Our ref: HA/2026/127495/01-L01
Your ref: BR/6/26/PL
Date: 03 March 2026

RETENTION OF ALTERATIONS TO 3 NO LISTED BUILDINGS, EXTENSION OF A LISTED BUILDING TO CREATE AN OFFICE AND WARDEN'S ACCOMMODATION, ERECTION OF 1 NO NEW BUILDING CONSISTING OF 3 NO FLATS, OFFICES AND WORKSHOPS, CREATION OF NEW PRIVATE GARDENS, SEPARATION OF THIS PART OF THE SITE FROM THE WIDER UNIVERSITY CAMPUS, CREATION OF A SHARED LANDSCAPED COURTYARD, AREAS FOR PARKING, AND STORAGE FOR BINS AND CYCLES. THIS APPLICATION OF LISTED BUILDINGS, AFFECTS THE CHARACTER AND APPEARANCE OF THE UPPER BOGNOR ROAD AND MEAD LANE CONSERVATION AREA AND IS IN CIL ZONE 4 (ZERO RATED) AS FLATS.

67, 69 AND 71 UPPER BOGNOR ROAD BOGNOR REGIS PO21 1HR.

University of Chichester
Upper Bognor Road Residential Redevelopment
Drawing
New Live Work Units
Ground Floor Plan Proposed
Scale @ A3
1:50 Drawing no.
5542-110-D2

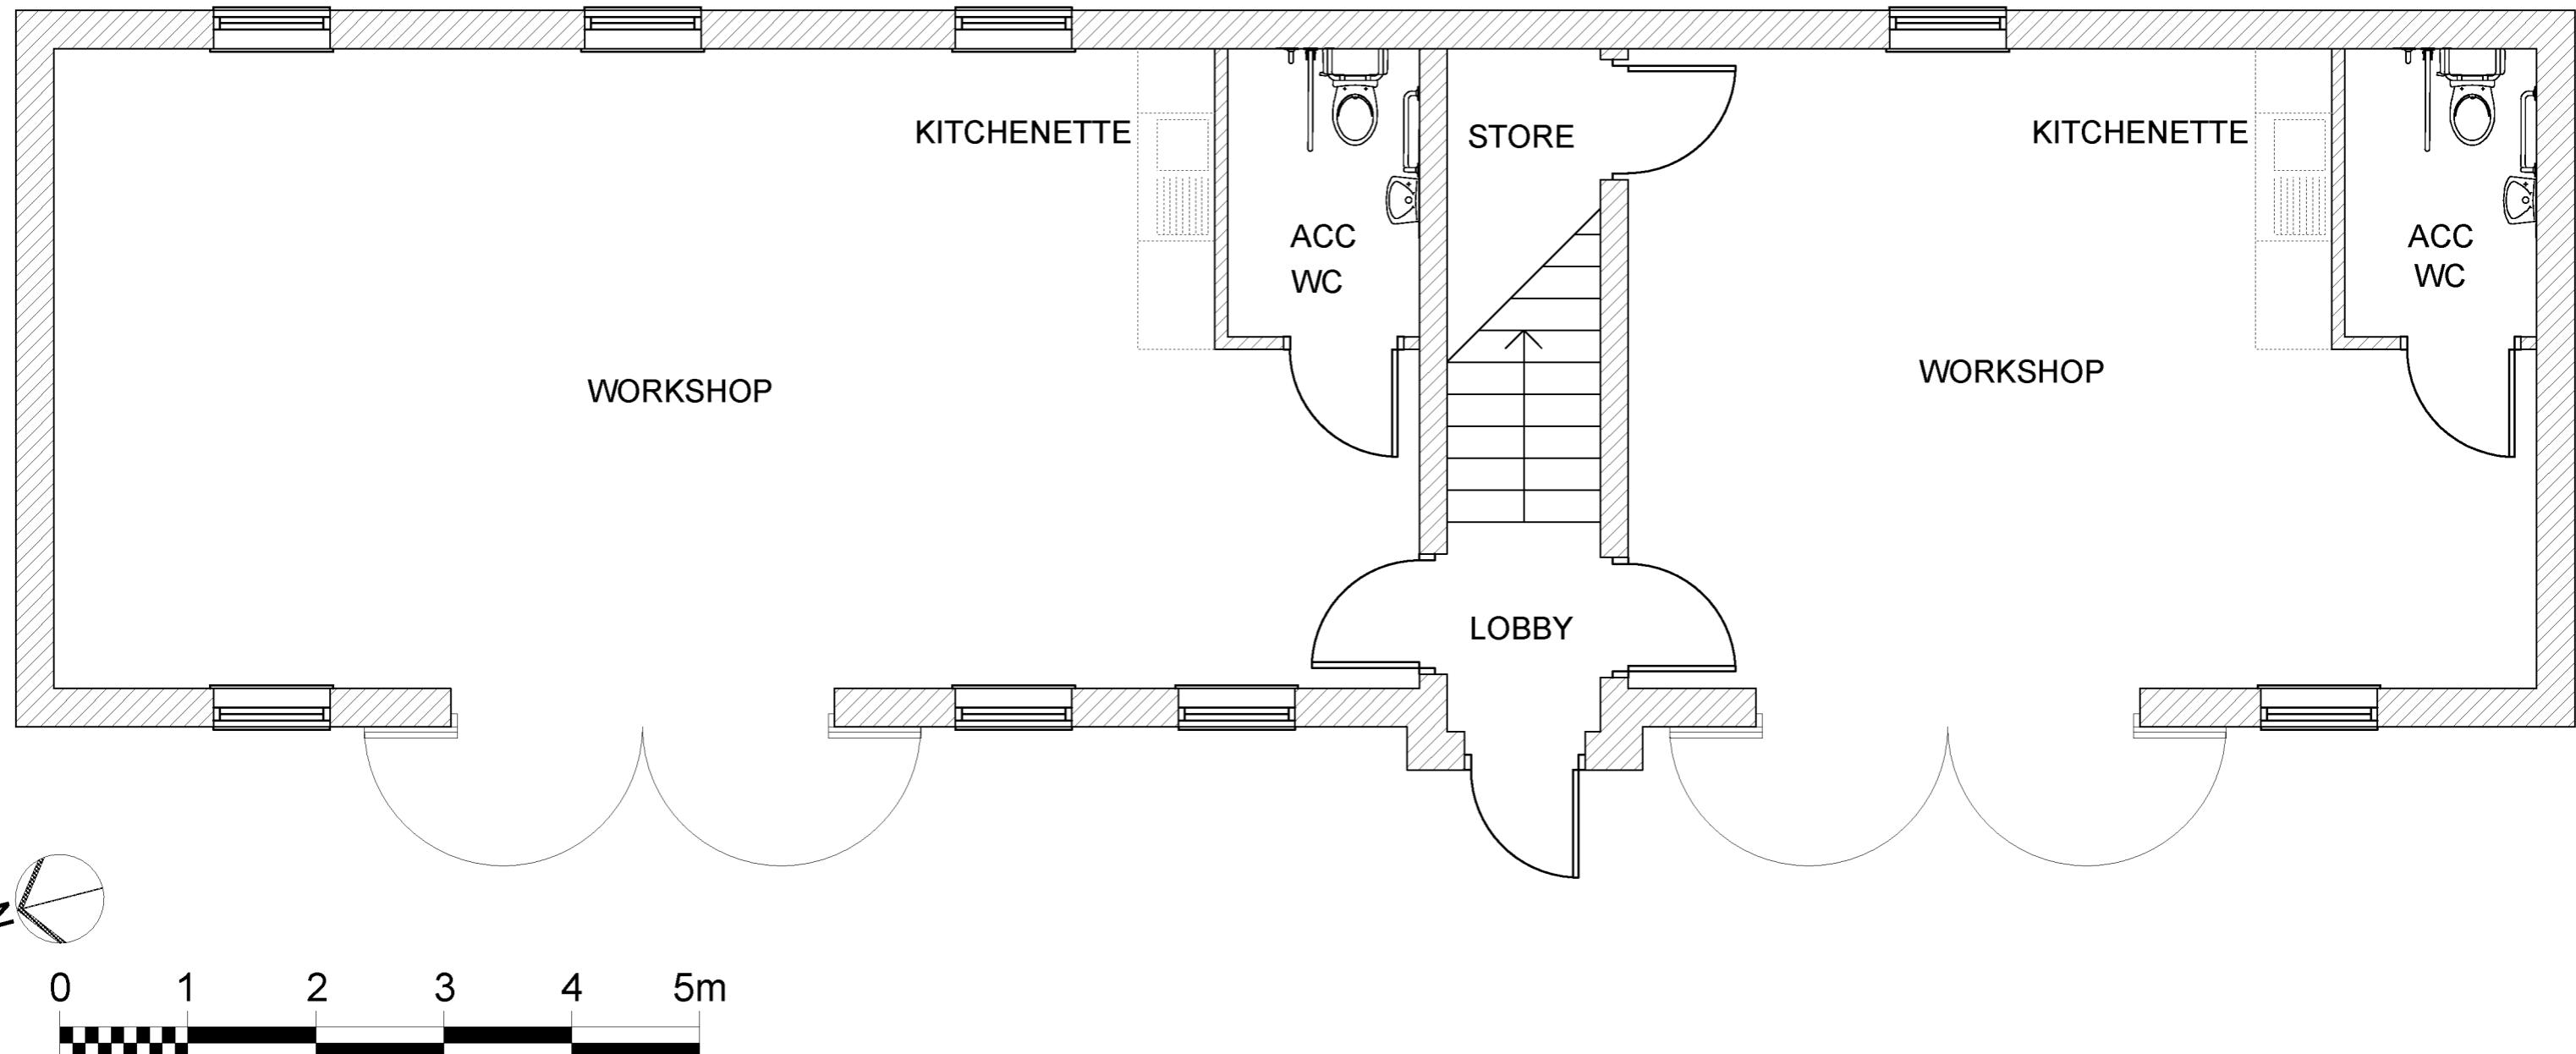
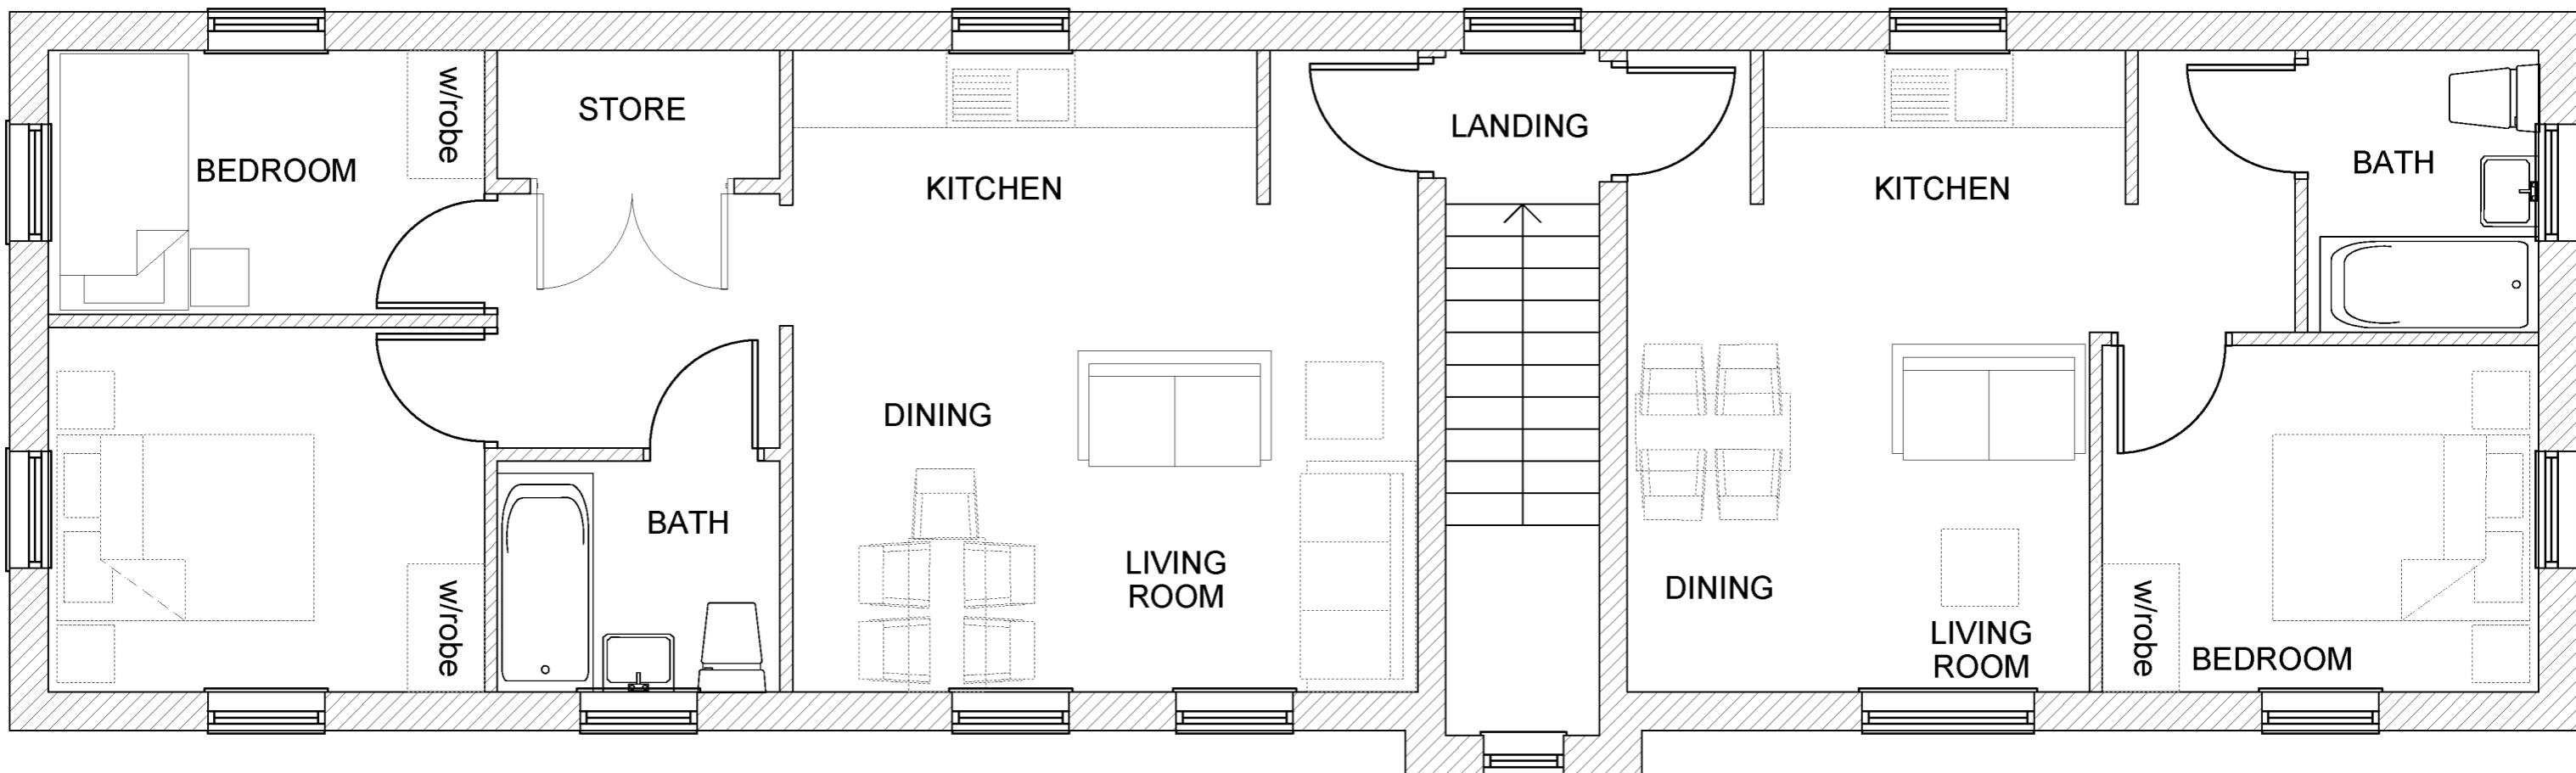
- Use the correct plans for the application
 - Only one building is referenced in the FRA, it should cover all buildings in the application
- Detail any finished floor levels for sleeping accommodation across the three buildings
- Take the impacts of climate change into account
 - Different climate change allowances have been used to assess future flood risk than those advised in '[Flood risk assessments: climate change allowances](#)', without adequate justification. A climate change assessment needs to be undertaken up to the year 2125.

To overcome our objection, the applicant should submit a revised FRA which addresses the points highlighted above. The application is retrospective. The building plans in the FRA do not appear to reflect what has been built. As such, the FRA should be updated to include the correct plans and should include details on the finished floor levels of the sleeping accommodation across all relevant buildings in the application. A climate change assessment should be included up to the year 2125.
